# Rezoning Transportation Analysis

Petition Number: 2021-112

Date	Description
09-21-21	First Review (BKB)

RZ-2: PARCEL IDENTIFICATION PLAN

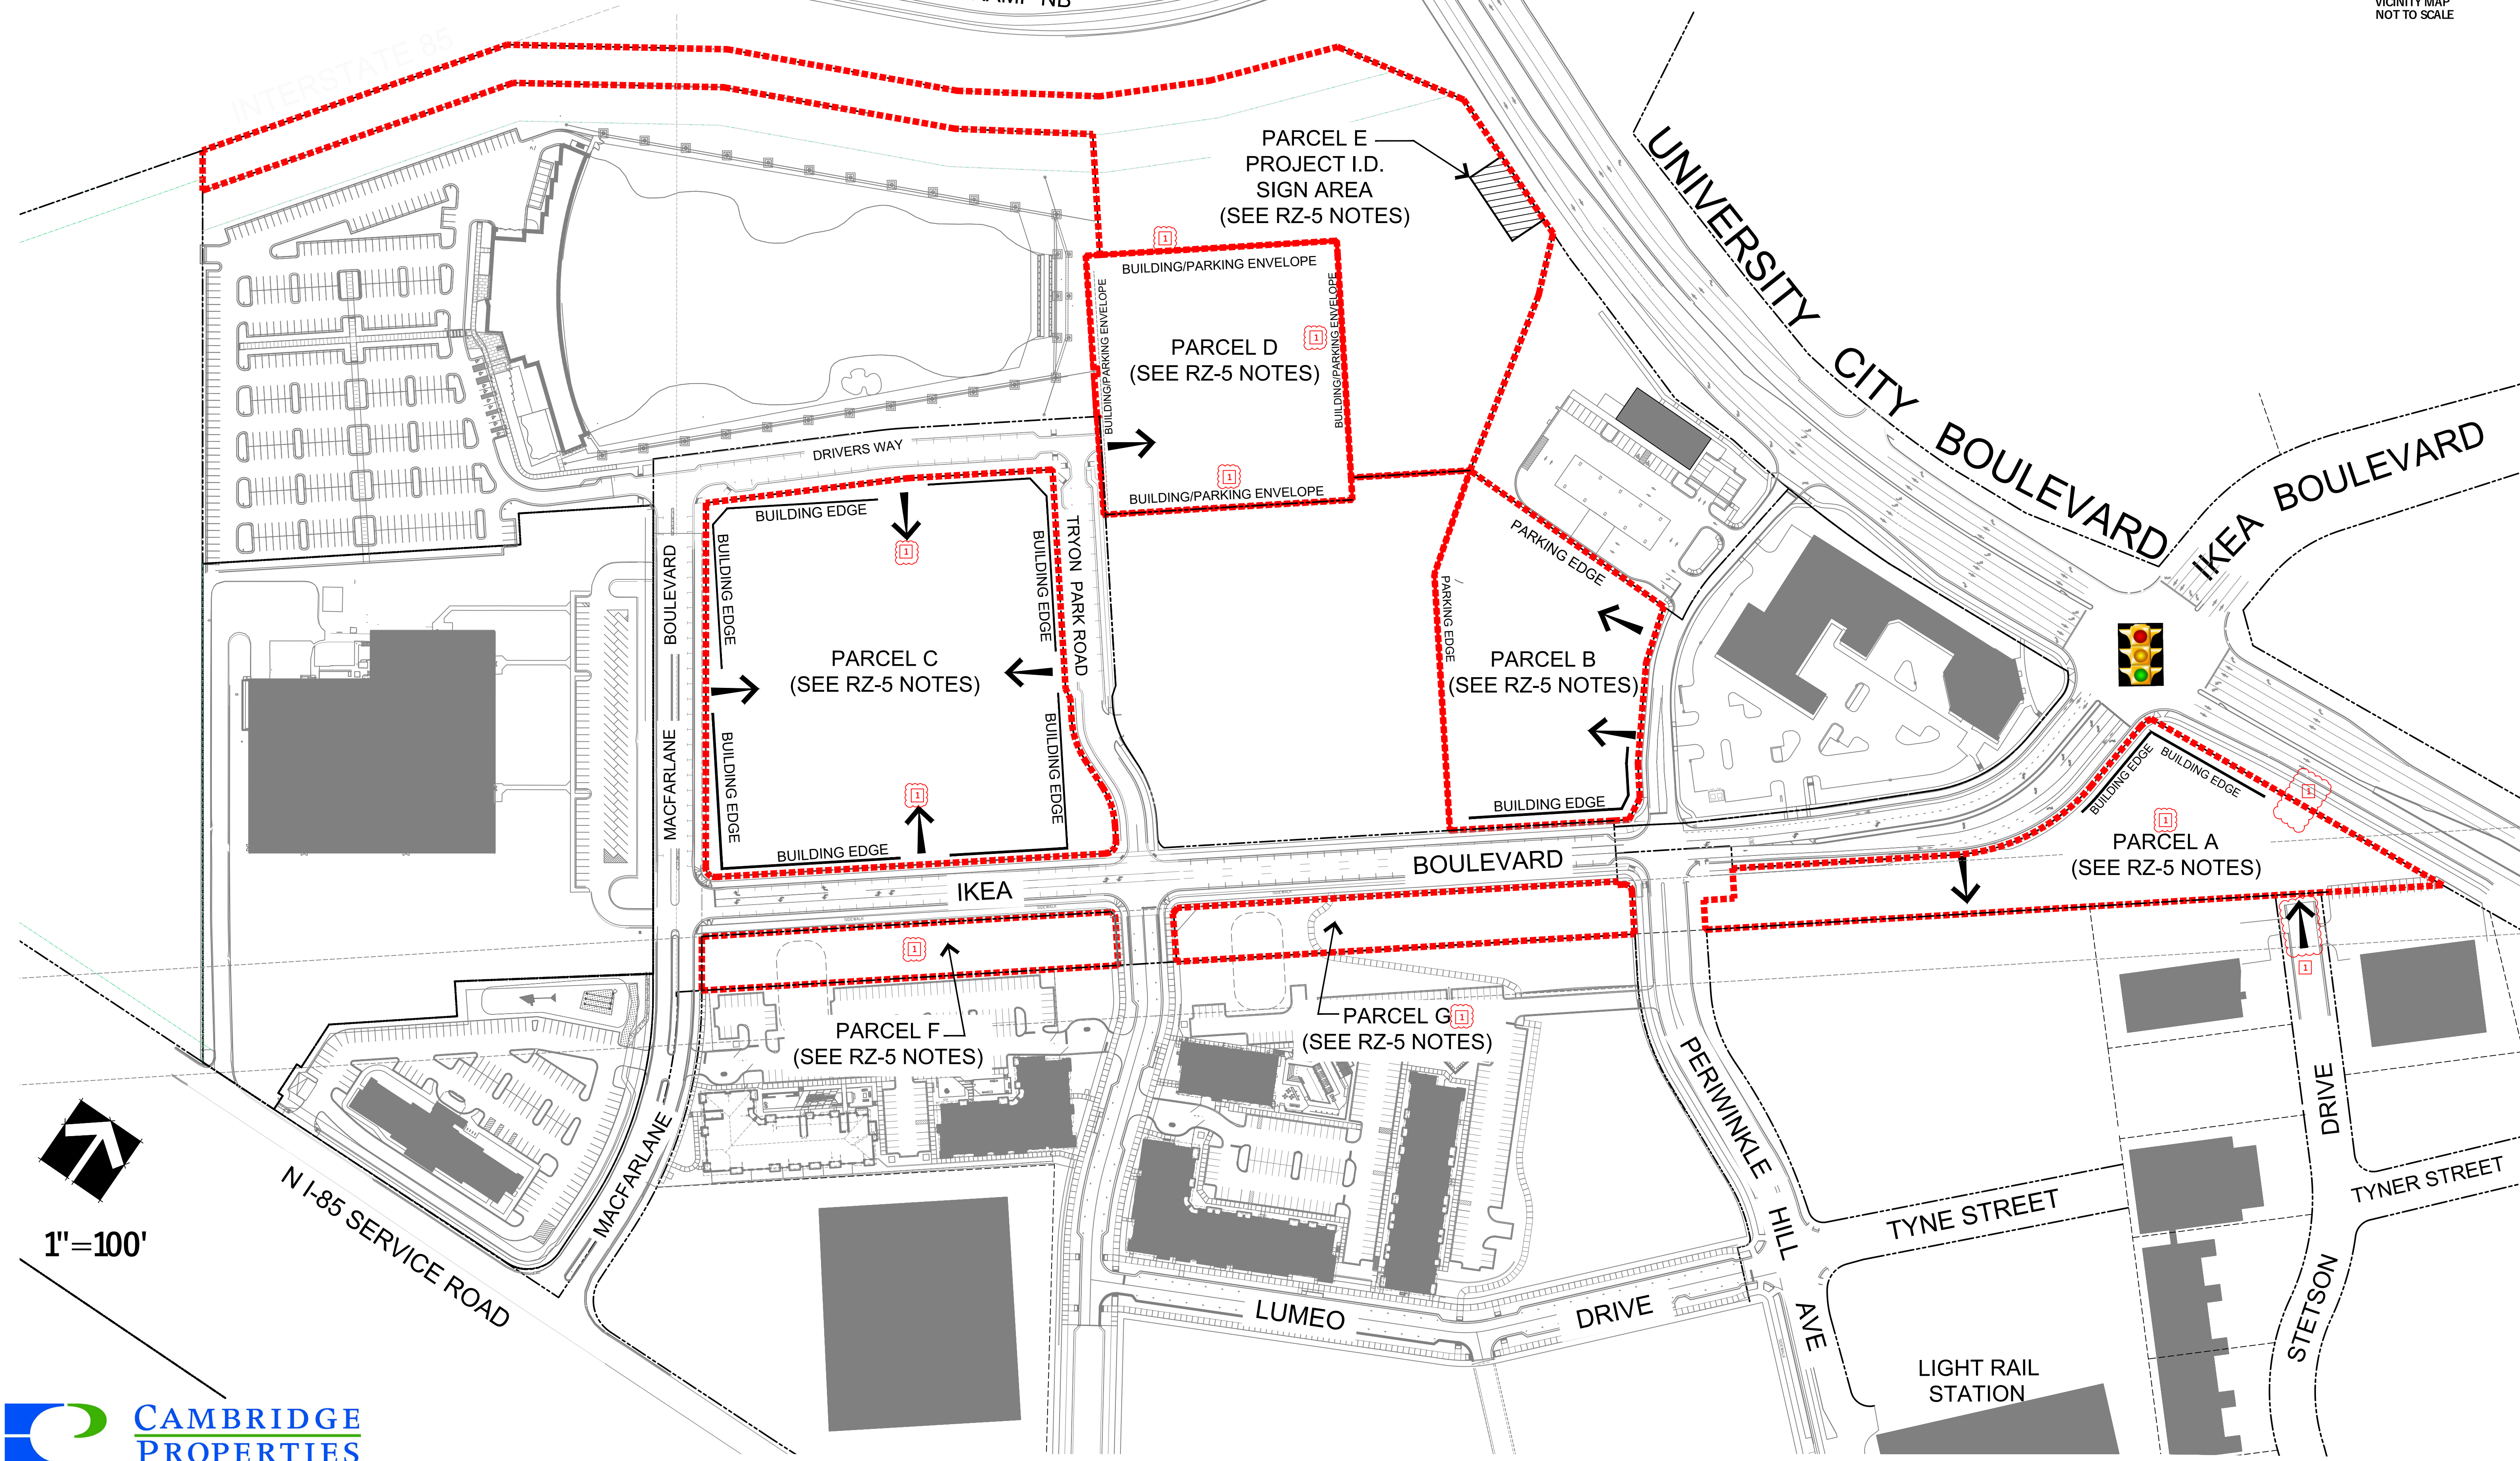
2. Access points are not permitted off of University City Boulevard. Revise site plan and general notes to reflect the access point to Parcel A being off Stetson Drive as opposed to the currently shown access point on University City Boulevard.
